Date: 15 January 2019  
Enquiries to: Jon Barnard  
Tel: 0345 603 1842  
Email: [jon.barnard@suffolk.gov.uk](mailto:jon.barnard@suffolk.gov.uk)

Your ref: TR010023  
Our ref: SCC/LLTC/EX/9

**Lake Lothing Third Crossing, Lowestoft, Suffolk ('LLTC' / 'the Scheme')  
DCO Application – Reference TR010023 ('the Application')  
Suffolk County Council ('the Applicant')  
Applicant's intention to submit a request for proposed scheme changes**

**MAINLINE LONG SECTION
(WORK NOS. 1A, 1B, 1C, 1D & 1E
WORKS PLANS SHEET NOS. 1 & 2)**

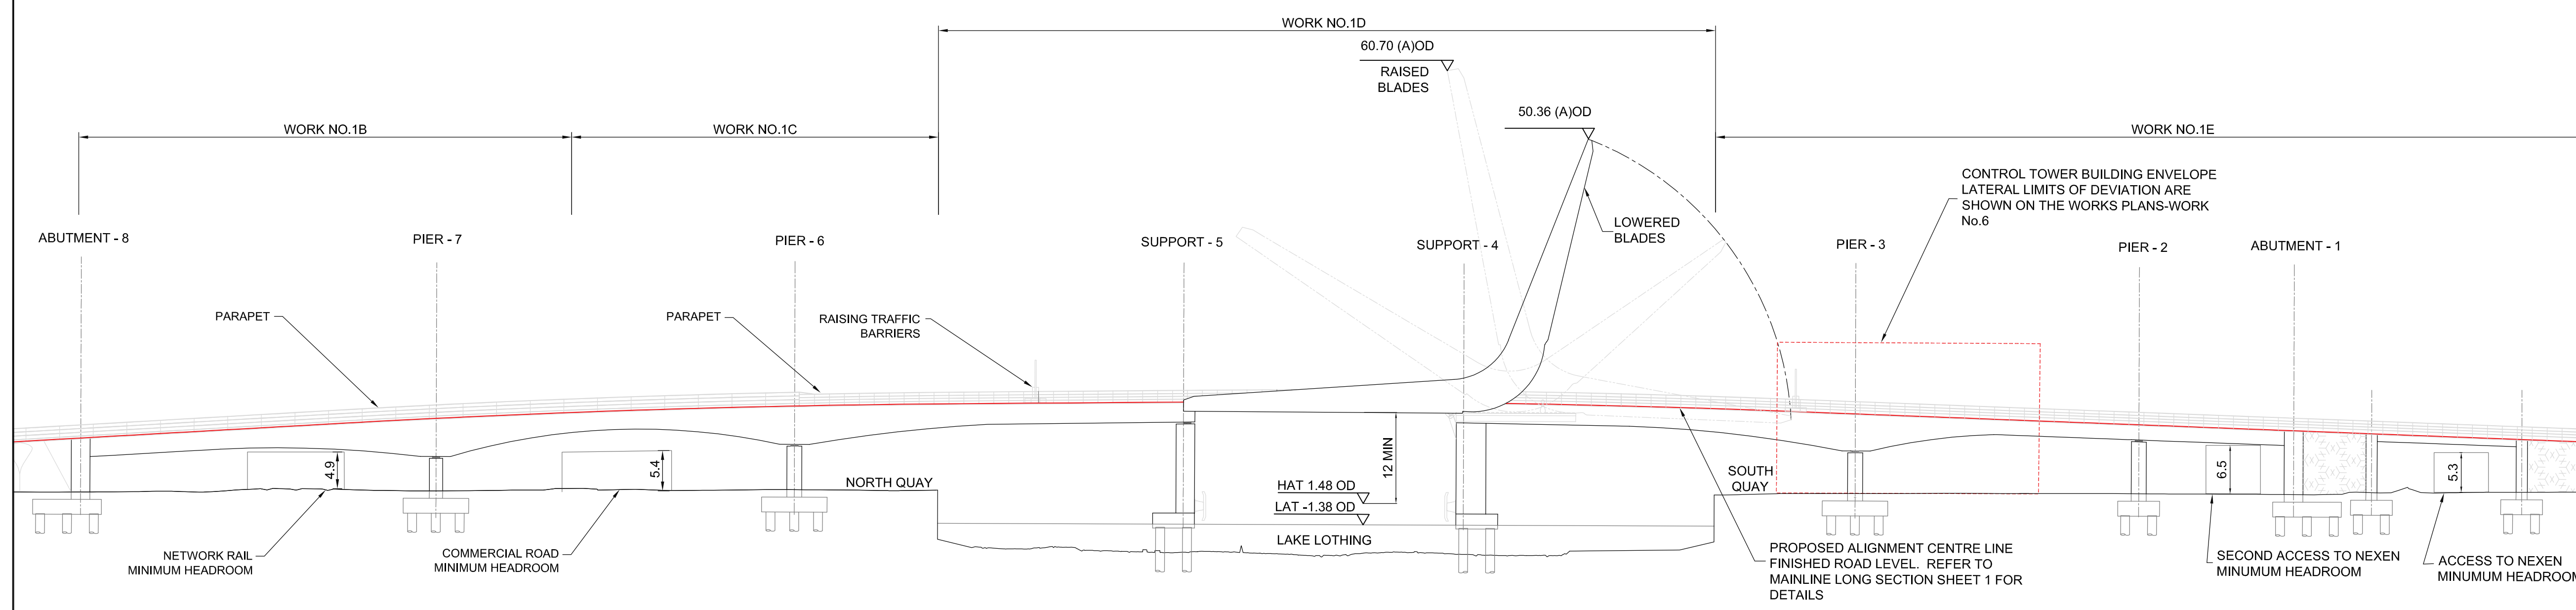
- 4.2 (ii) As the Applicant has set out in its Deadline 3 submission, in particular its response to ExQ1.1 (see REP3-029, in particular Appendix A), it is preparing an update to Mainline Long Section Sheet 2 of 2 [APP-041] to show more explicitly how the LoDs in DCO article 5 relate to the finished road levels shown on that drawing. The Applicant also proposes to reflect in this drawing and article 5 the LoDs as they apply to the 'blades' of the opening section of the new bridge. The Applicant proposes to explain how the LoDs that the Applicant seeks relate to the reference design, as assessed in the Environmental Statement. This change would not require any land currently outside the Order limits or any additional land in the context of the CA Regulations.

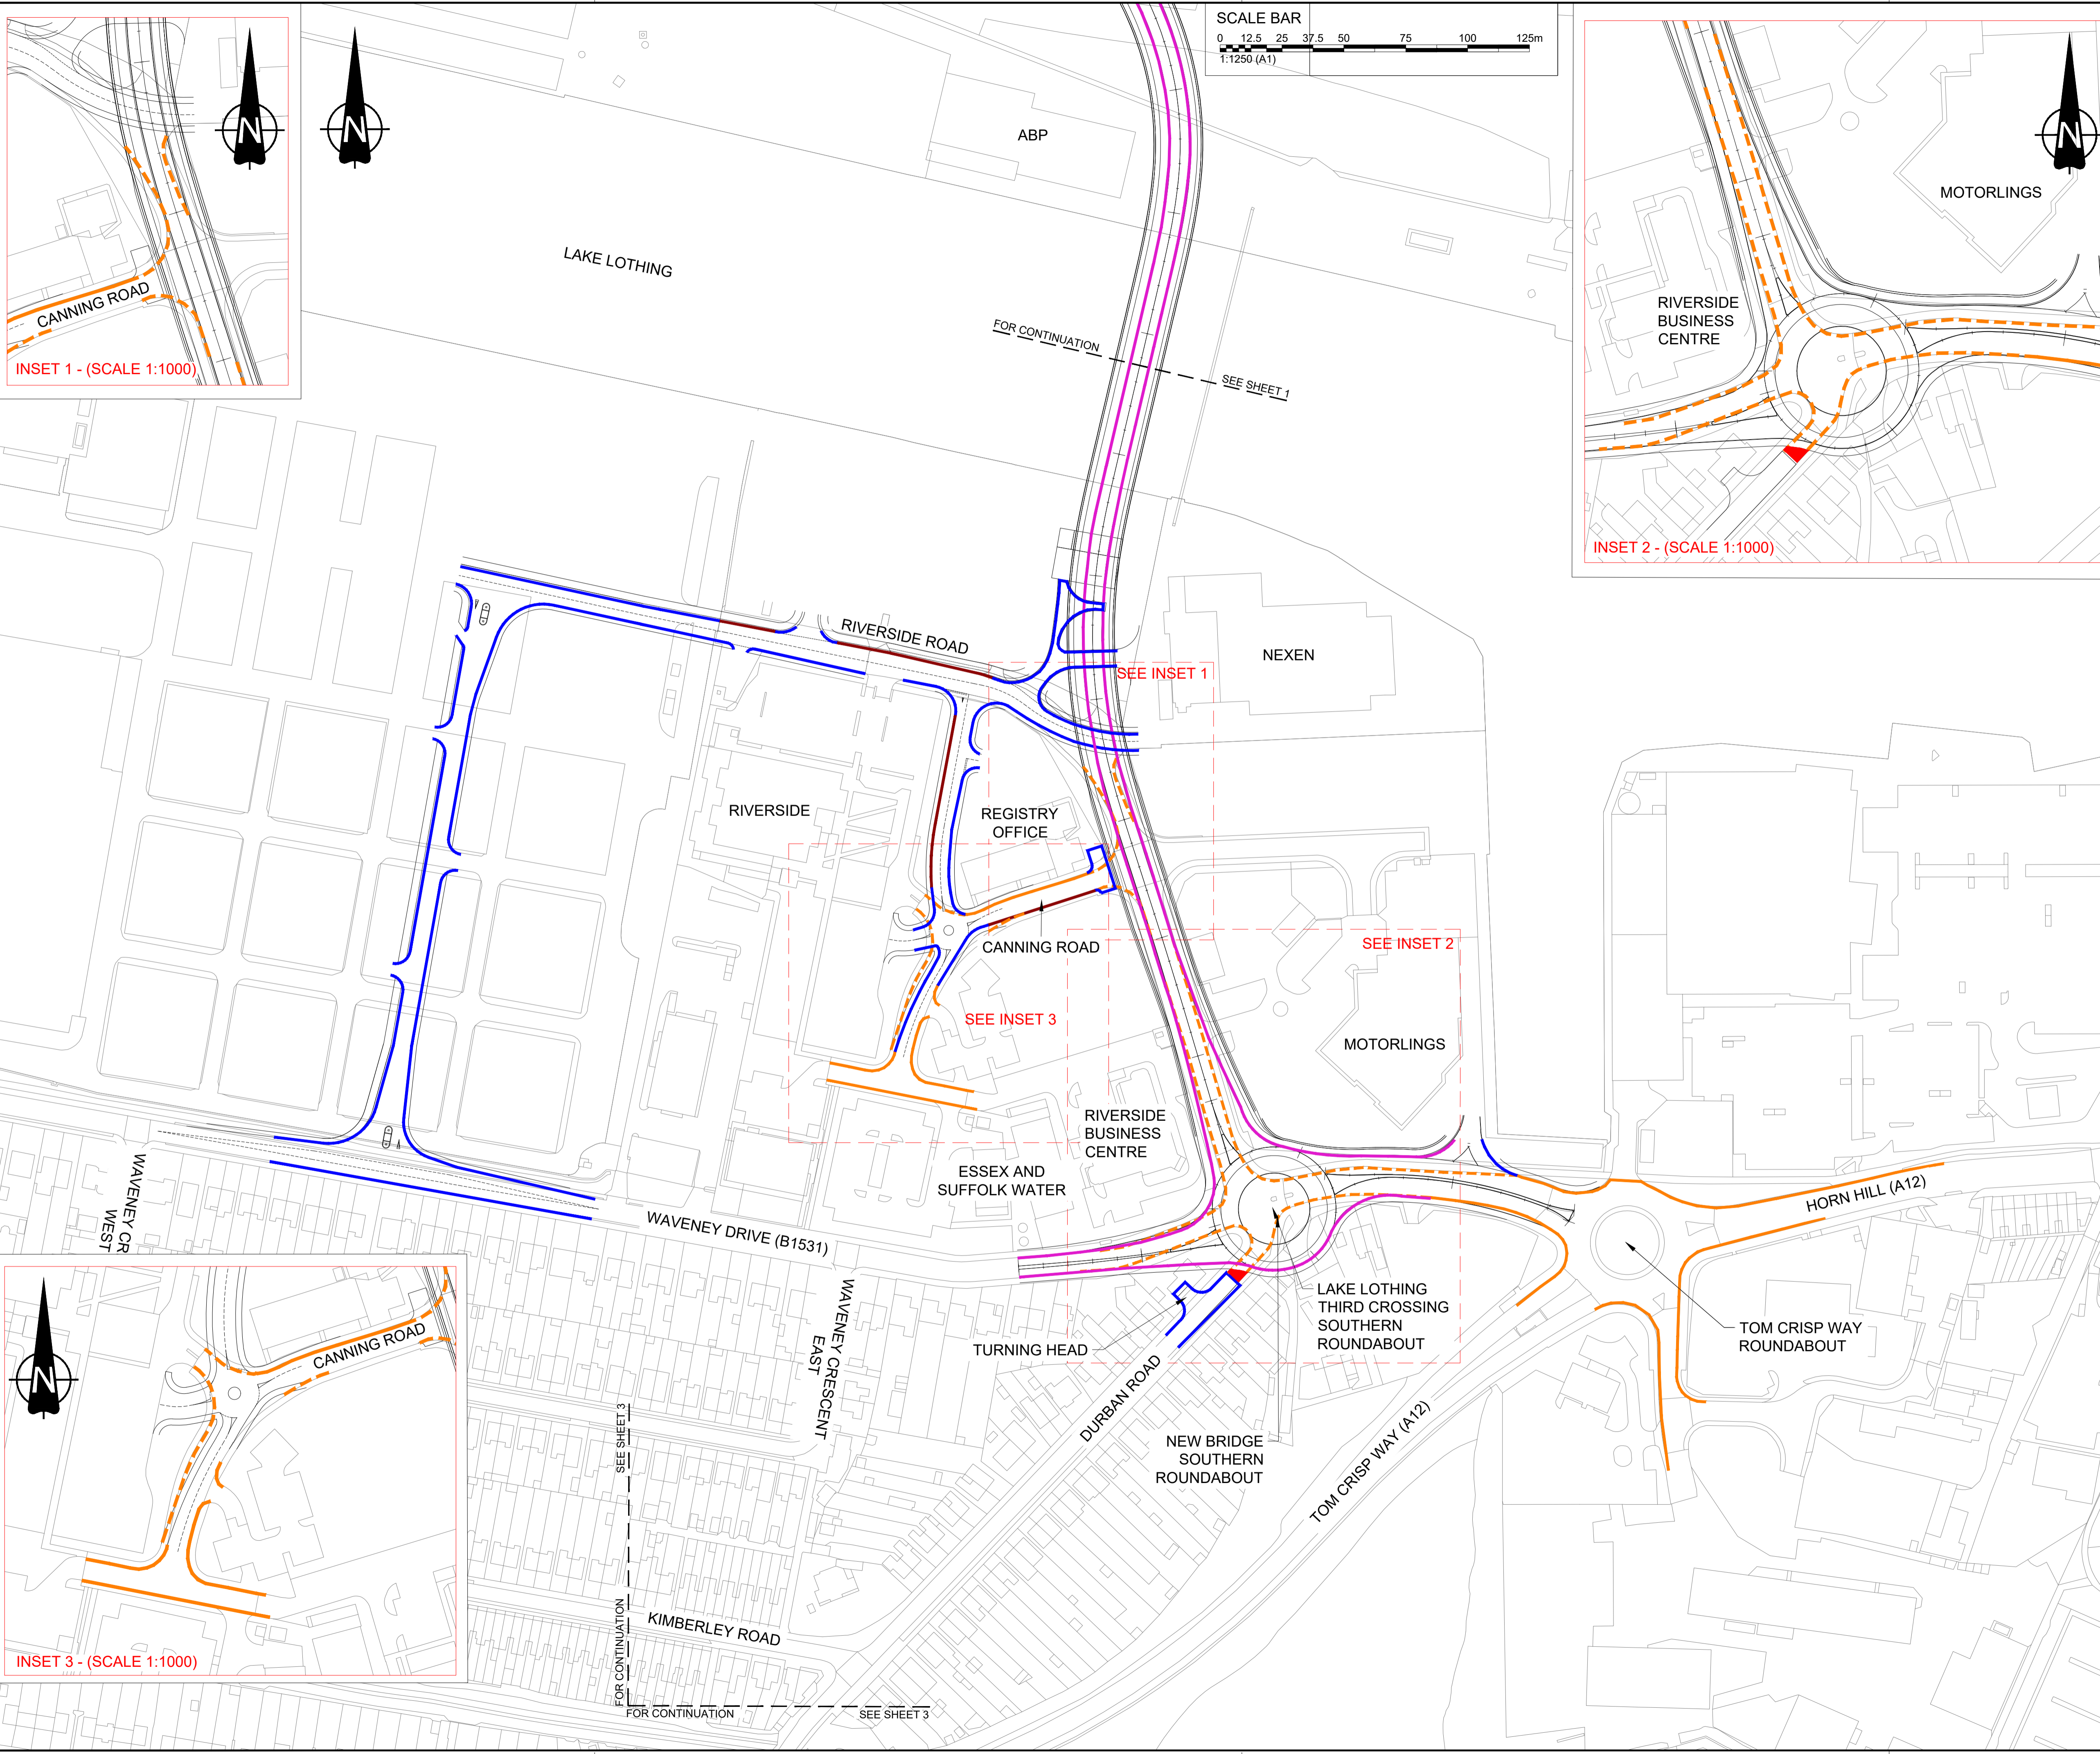
- 2.1 For the reasons set out in the Applicant's Responses to Relevant Representations [AS-013] (specifically, in the response to RR-017 submitted by Northumbrian Water Limited – see issue references HT14 and DCO15) the Application as originally submitted includes traffic regulation measures which would reduce the amount of available on-street parking in Riverside Road and Canning Road.

- 2.2 However, having had regard to the points raised in Relevant Representations, the Applicant would be prepared to allow some on-street parking provision to be retained in Riverside Road and Canning Road.

- 2.3 Accordingly, the Applicant proposes to amend the parking restrictions currently proposed in the draft DCO and the related Traffic Regulation Measures (Prohibitions) Plans (see sheet 2 – APP-030) to reduce the extent of the currently proposed 'no waiting' and 'parking limited to 2 hours' restrictions, thereby allowing more on-street parking on certain parts of Riverside Road and Canning Road.
